Recommendation Report for Planning Permission for Works or Extension to a Dwelling

REF NO: M/15/19/HH

LOCATION: 1 Tudor Close
Middleton-On-Sea
PO22 6DN

PROPOSAL: Two storey side/ front extension

Proposed South Elevation

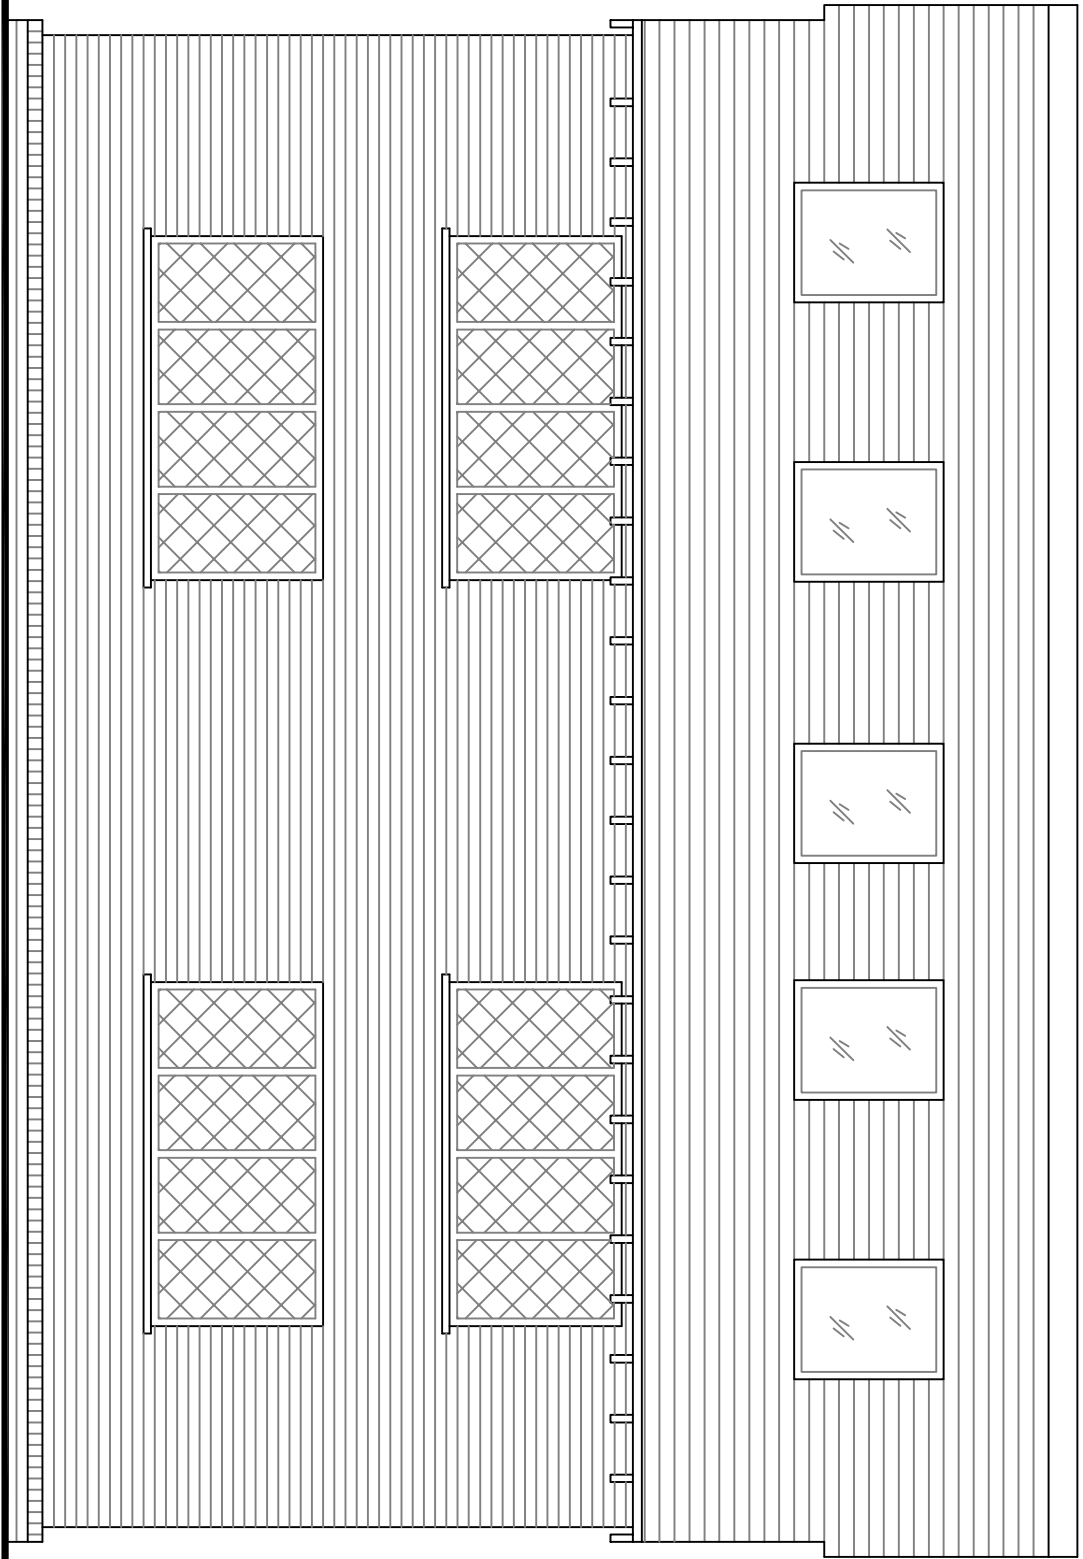
The proposed development represents a significant change to the appearance of the host dwelling, as a result of its significant scale, and siting. The proposed development is not considered to be a subservient addition to the host dwelling, as it matches the ridge height of the host dwelling, and constitutes an increase of 64% to the footprint of the host dwelling, as it adds 44.06sq.m. of floor area to the host dwelling, which is 68.4sq.m. Therefore, the proposed development is not considered to be in accordance with D DM4(b) of the Arun Local Plan. Whilst it is considered that the proposed development is not visually subservient to the host dwelling, it should be noted that as a result of the size of the residential plot, the proposed development is considered to respond well to the scale of the plot, and is subservient when compared to the size of the residential plot, therefore is not considered to compromise overdevelopment of the residential plot.

As a result of the design of the proposed extension, it is considered to appear well integrated with the host dwelling, resultant of its siting, design and use of materials. The design of the proposal and the matching materials allow the extension to have no significantly harmful impact upon the character of the host dwelling, as it is considered to resonate with it, in terms of character and appearance. This is helped by the design of the roof being of a similar design to the existing Eastern projection of the host dwelling. Additionally, as a result of the boundary treatment, there are very few available views of the proposed development from the street scene, which is considered to allow the proposed development to have no significantly harmful impact upon the character of the locality. There will be some views of the Southern aspect of the roof of the proposal, it will be conditioned that roof light details are confirmed, in order to ensure that they are of an acceptable design.

The proposed development is not considered to have any significant overbearing or overshadowing impact upon occupiers of nearby dwellings. This is as a result of the siting of the proposed development on the Southern side of the host dwelling, which is the aspect of the host dwelling sited furthest from neighbouring dwelling, as it faces the street scene of Middleton Road. With regard to loss of privacy, the proposed dwelling does not feature any windows that would result in any loss of privacy to occupiers of nearby dwellings, due to ample separation distances. Therefore, the proposed development is considered to be in accordance with D DM1(3) and D DM4(c) of the Arun Local Plan.

- 3 Prior to construction above DPC level, details of the roof lights featuring on the Southern roof slope of the proposal must be submitted to and approved by the Local Planning Authority and the materials so approved shall be used in the construction of the extension.

Proposed Site Extension Proposed Plans and Elevations Planning
Date January 2019
Scale 1:50

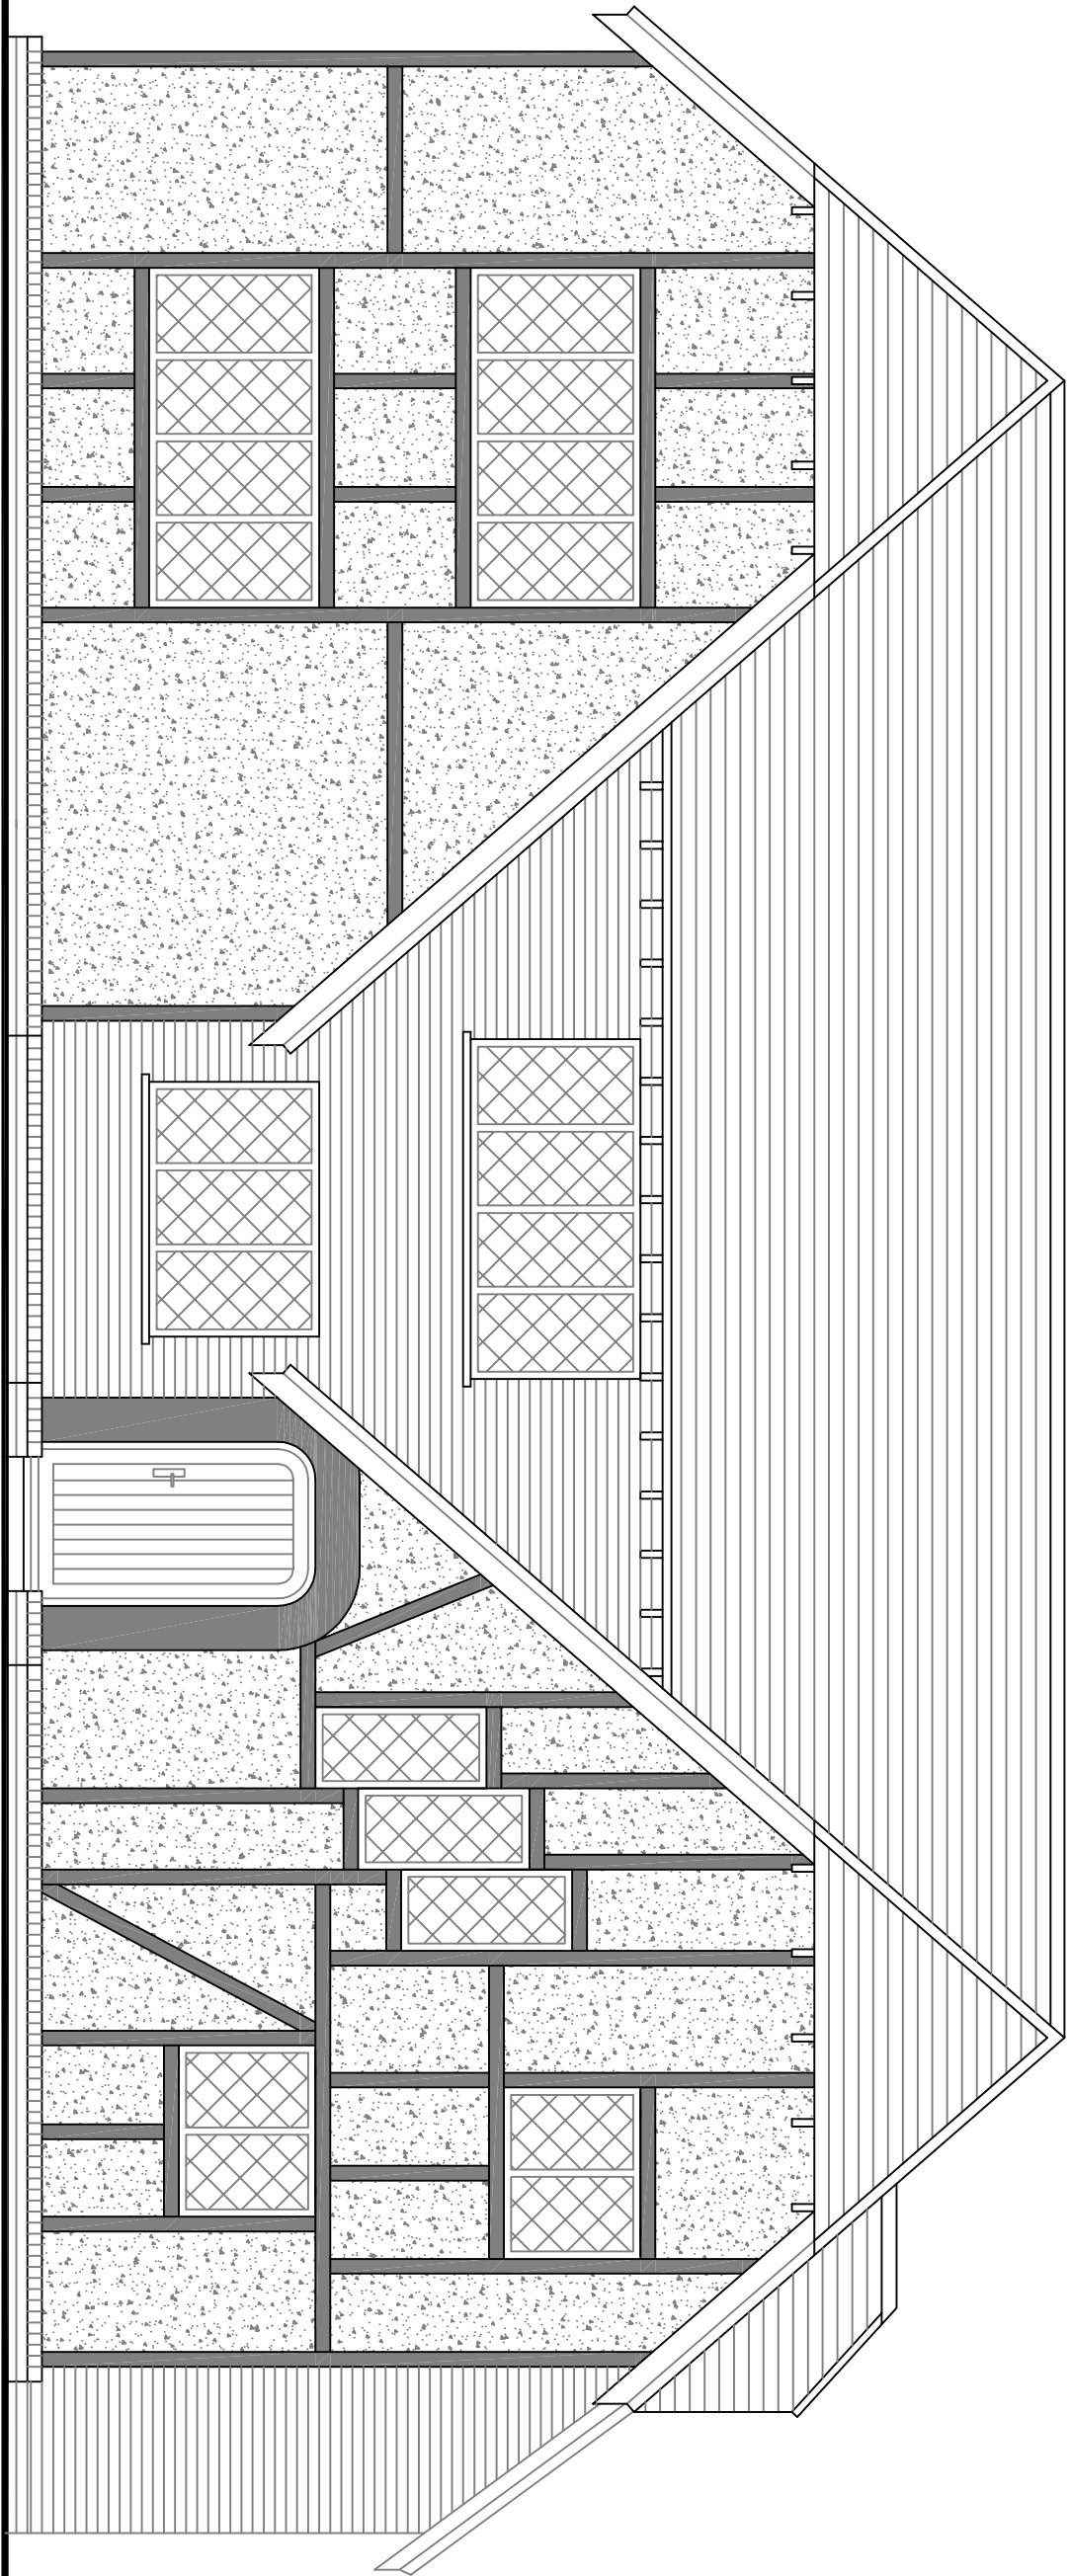
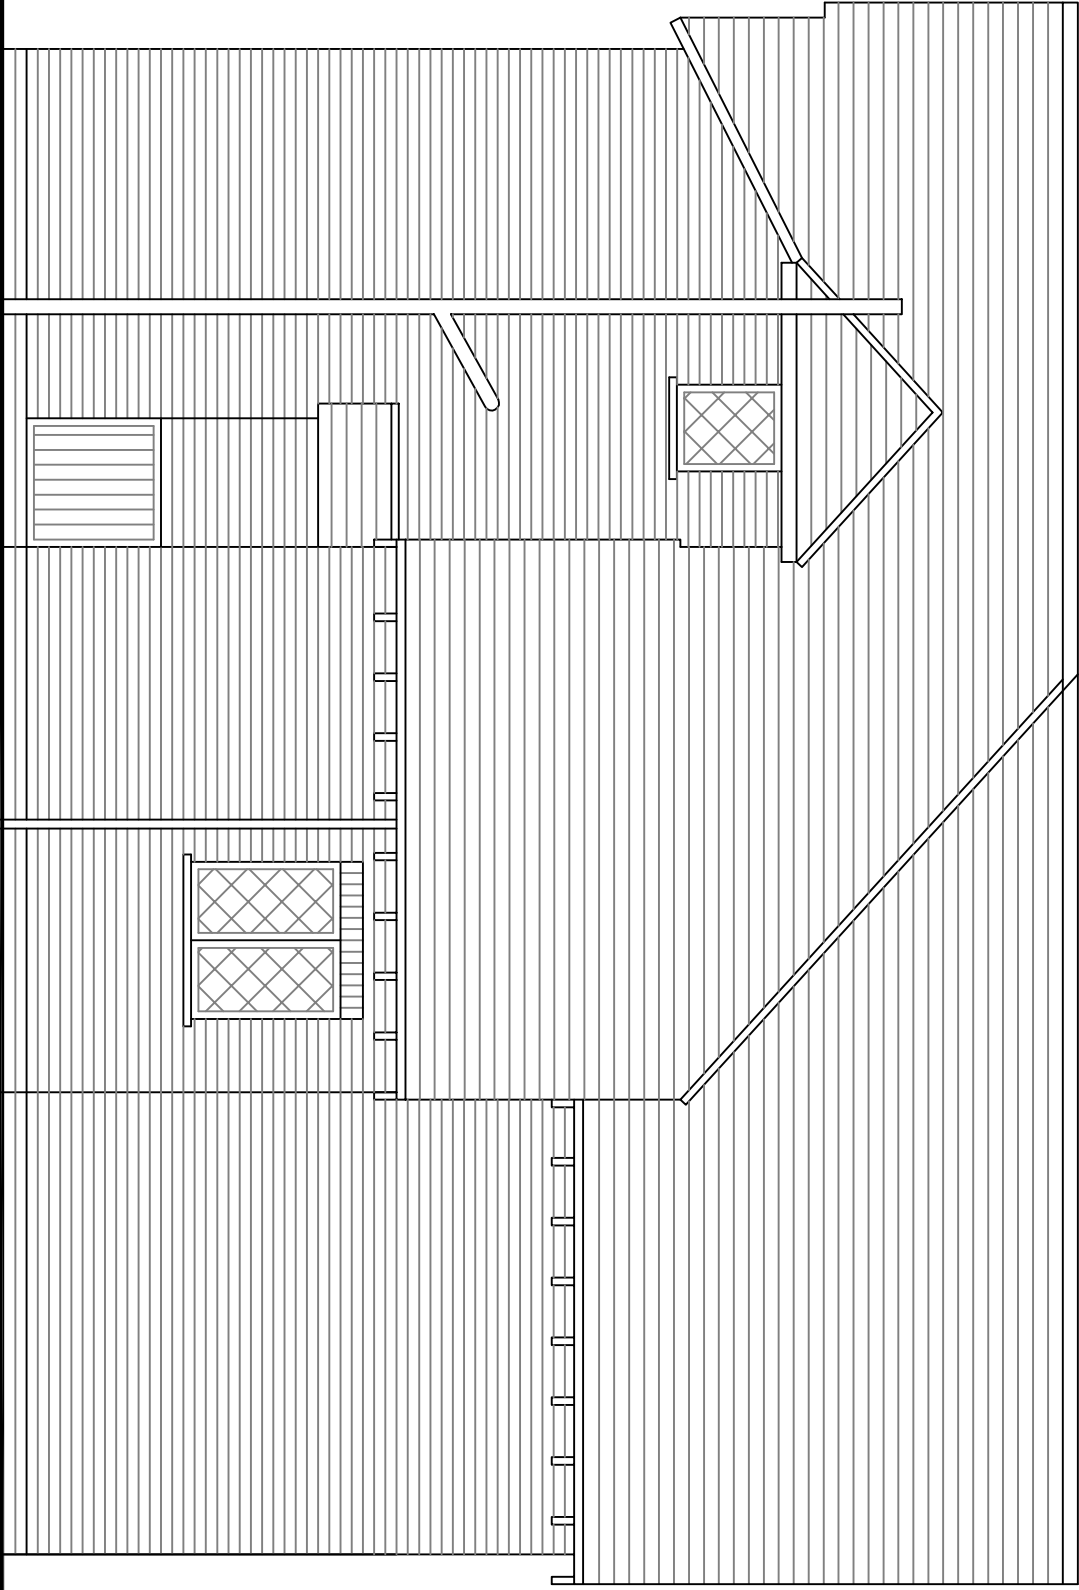
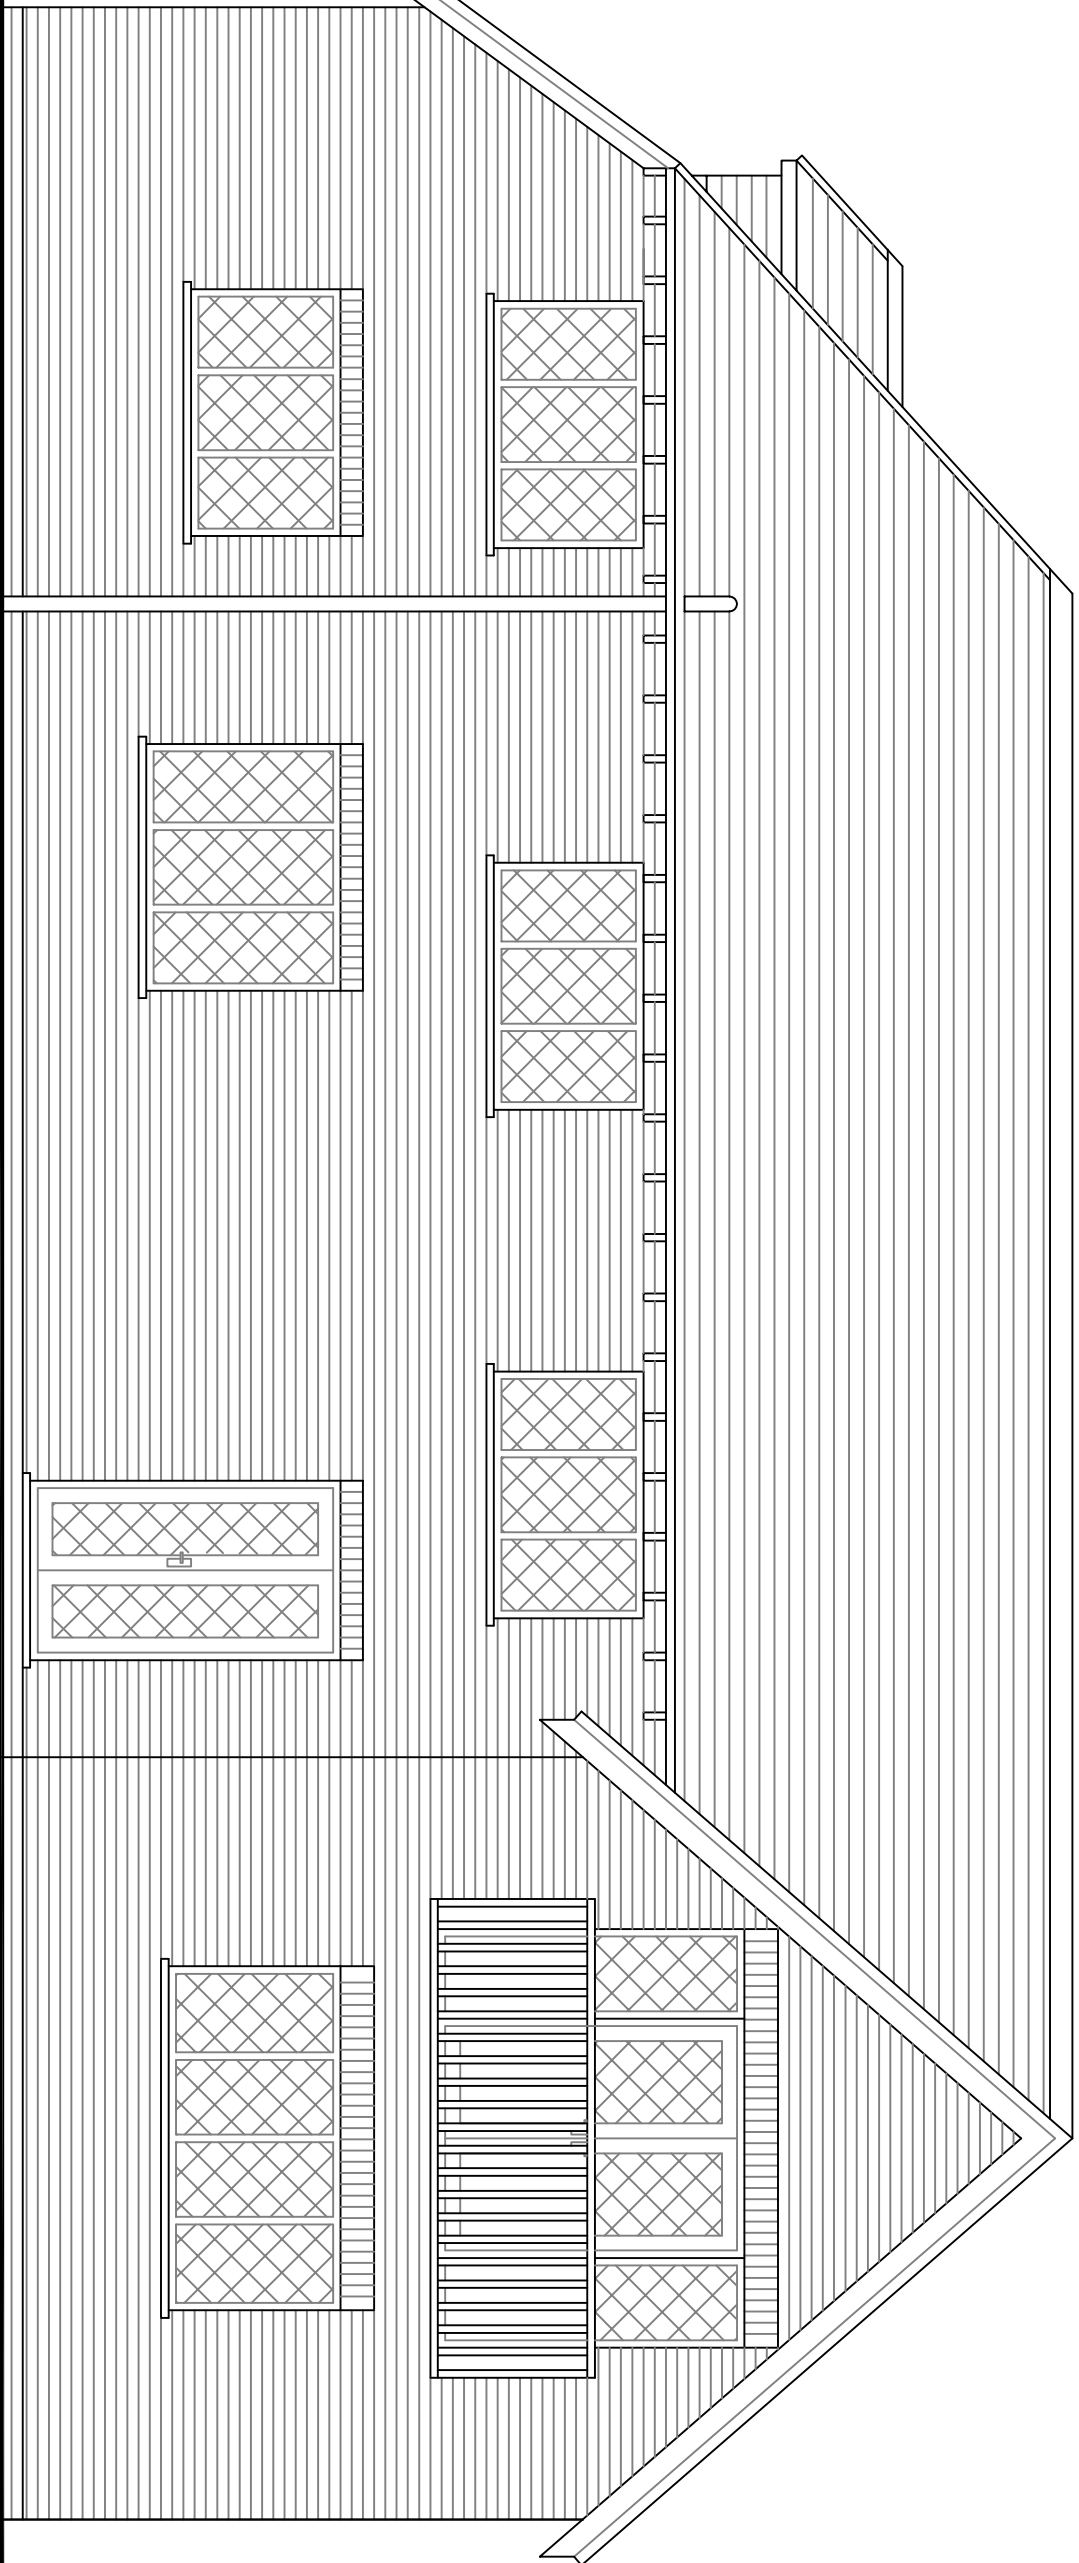
Therefore, whilst the proposed development is considered to be in conflict with D DM4(b) of the Arun Local Plan, it is in accordance with D DM1, D DM4(a) and (e) of the Arun Local Plan.
